Sang Hou
7022 E Mercer Way
Mercer Island, WA 98040
shoumkle@gmail.com

Ms. Nicole Gaudette
Senior Planner
City of Mercer Island Development Services Group
9611 SE 36th St
Mercer Island, WA 98040

RE: Critical Area Review Application CAO17-010. Response to questions issued in the May 10, 2018 city letter.

**CRITICAL AREAS MITIGATION PLAN
 PROPOSED SITE PLAN, IMPACTS & MITIGATION PLAN
 HOU PROPERTY
 MERCER ISLAND, WA**

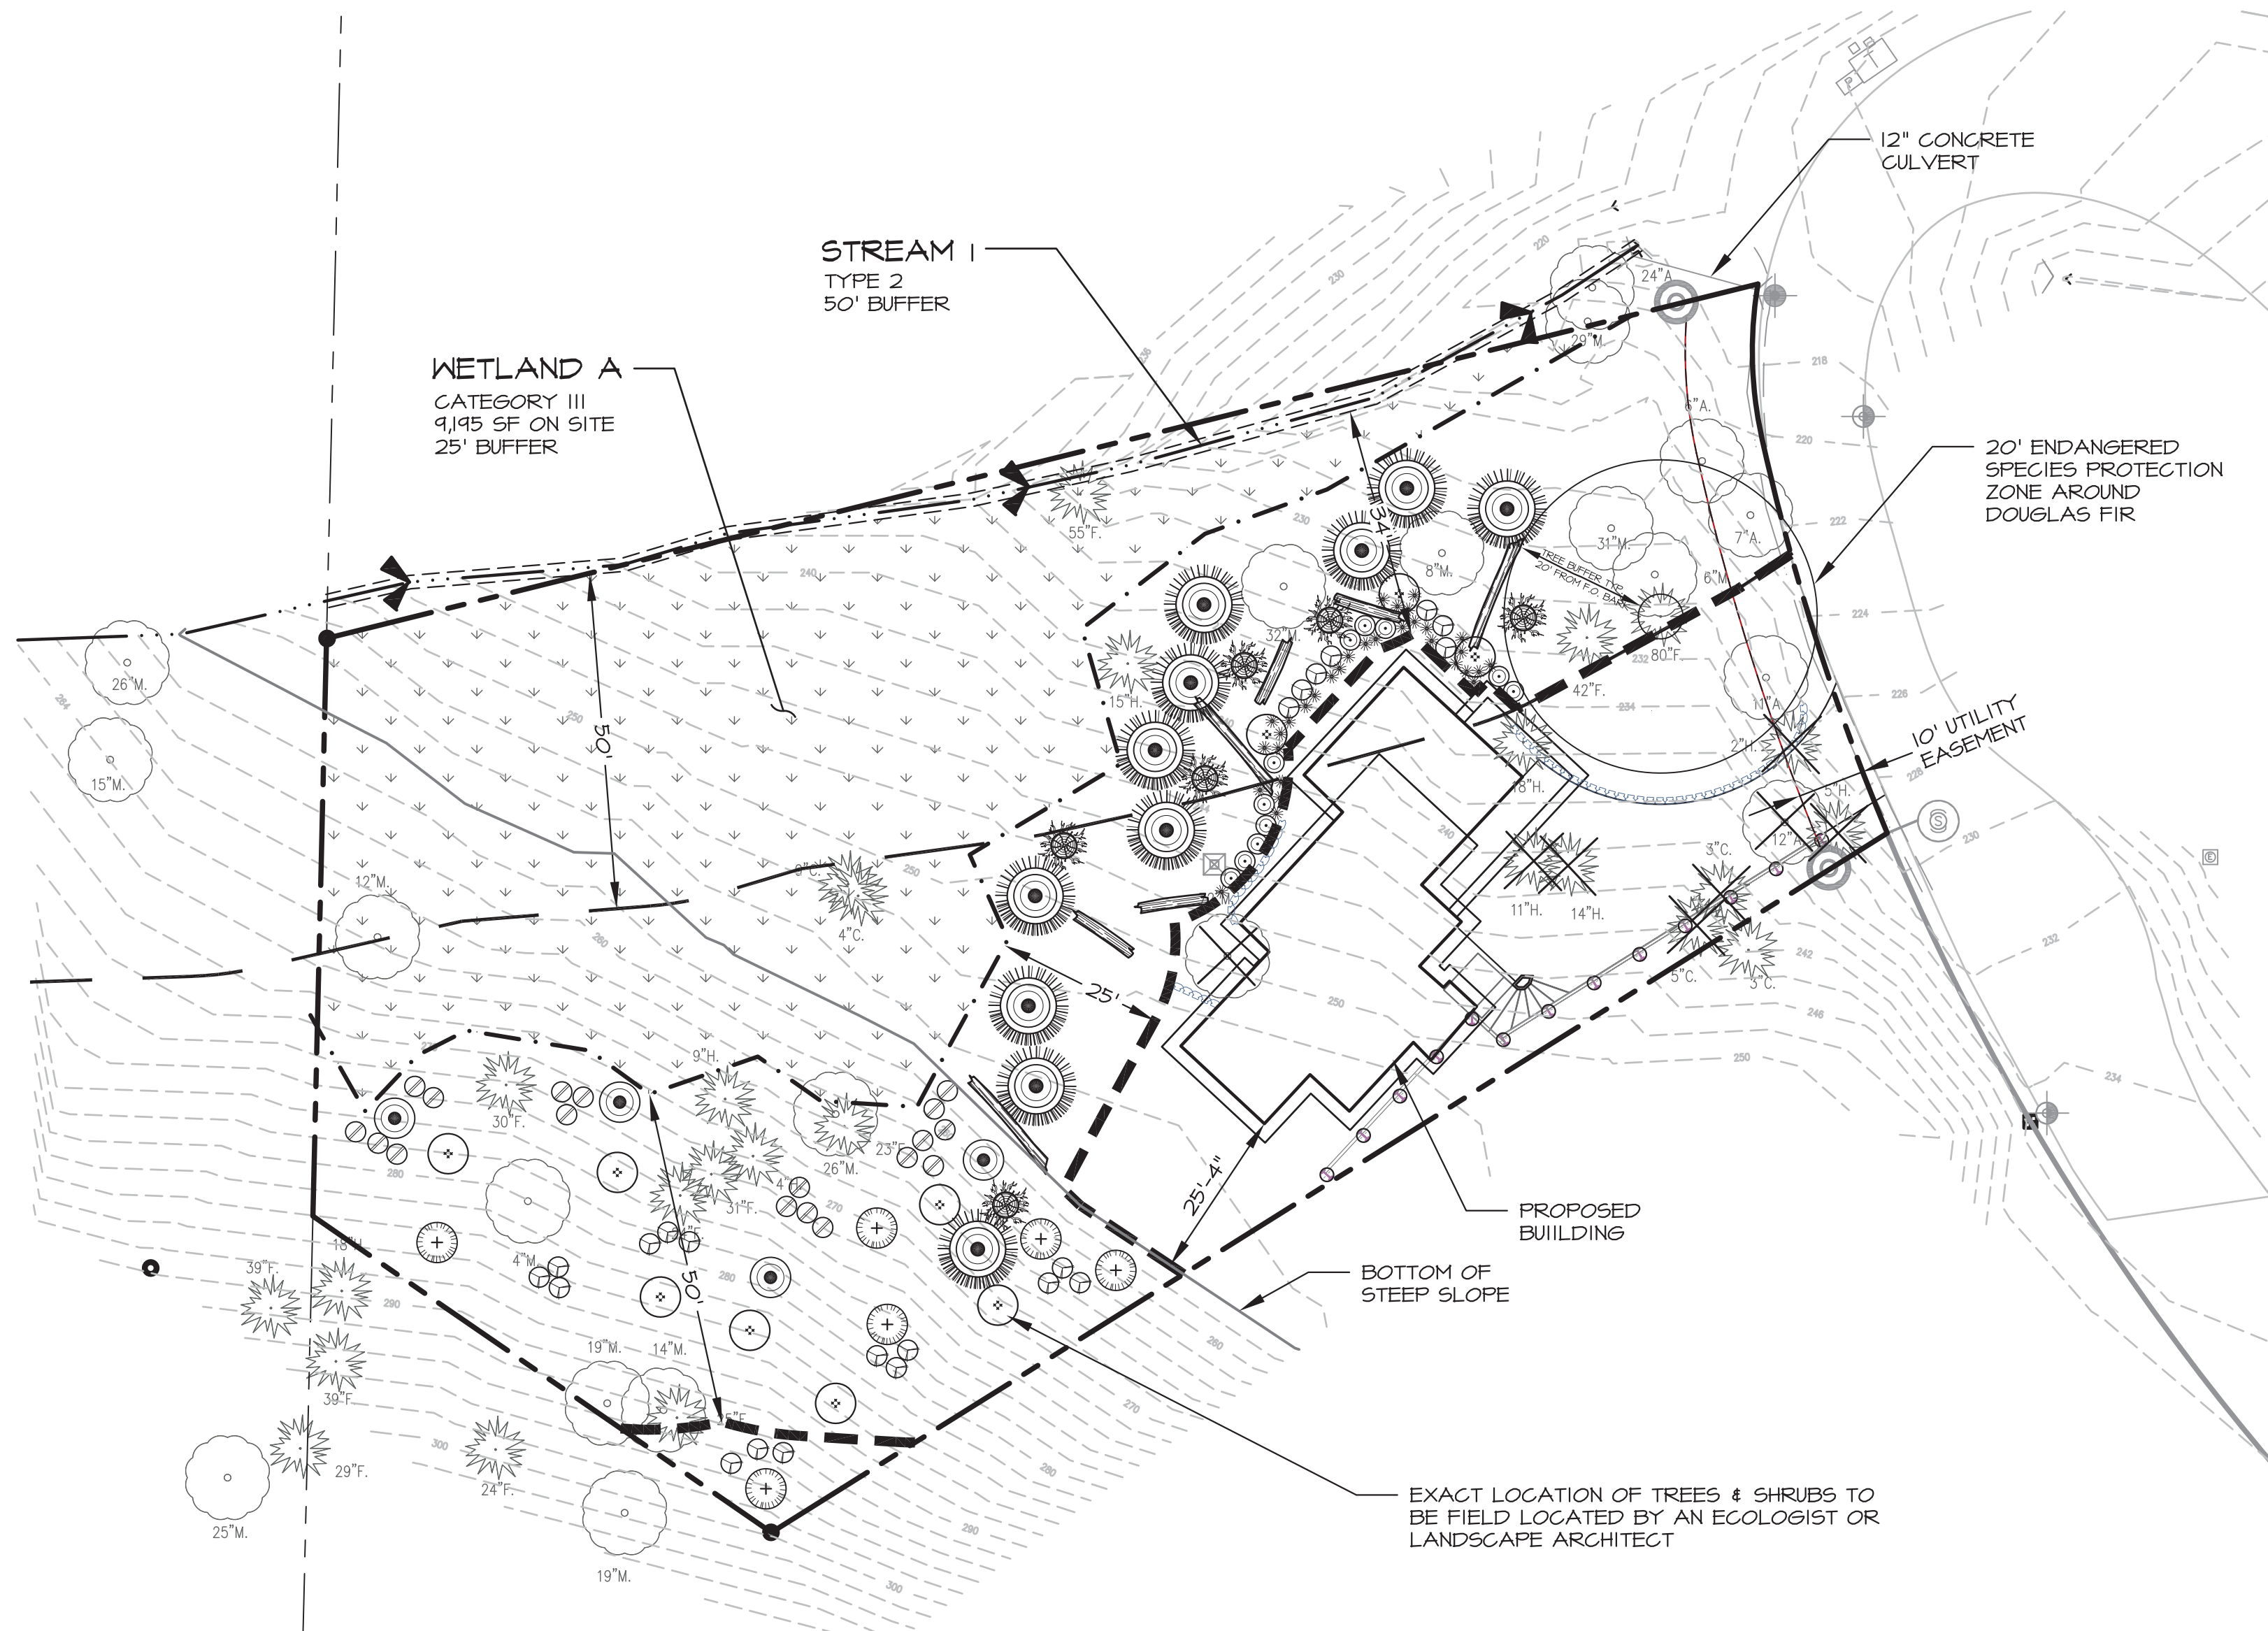
- 1. Please indicate on the project plans where drainage from the proposed house and driveway will go (Will it be directed to the stream? Will it be directed to the ditch?).***

- 2. It appears the exterior of the proposed house is too close to the proposed buffer. Identify the area of construction on the plans and determine what construction and future home maintenance activities will occur and how these can occur without disturbing the buffer. There will likely need to be more space between the proposed home and the proposed buffer than shown on the plans to accommodate these activities without disturbing the buffer. Please provide the needed setback from the buffer on the plans.***

No storm water will be discharged directly to the stream or any other critical area. The plans prepared 10 years ago called for retention/detention facility and will still include one to be constructed to retain drainage water on site and subsequently discharged at a moderated rate. Water retained/detained will be metered out into the buffer using a level spreader. No construction will be necessary in any critical areas to manage stormwater.

As stated previously, the house footprint for the critical areas review is hypothetical but is based on an actual plan previously contemplated for the site. Being that there have been code changes since the plans were previously reviewed as a building permit application, the plans will need to be revised accordingly. It is important to first establish a site building limit envelope prior to revising plans for subsequent building permit application. At that time, it is anticipated that the building being submitted for plan review will comply with all conditions as determined

through the critical area study review. Regarding the south boundary of the site, we anticipate a 10-foot building setback requirement from the south property line. Regarding the comment referencing adequate setback from the buffers, we will have a building setback of 5 feet to allow full passage around the entire building without having to enter into the buffer.
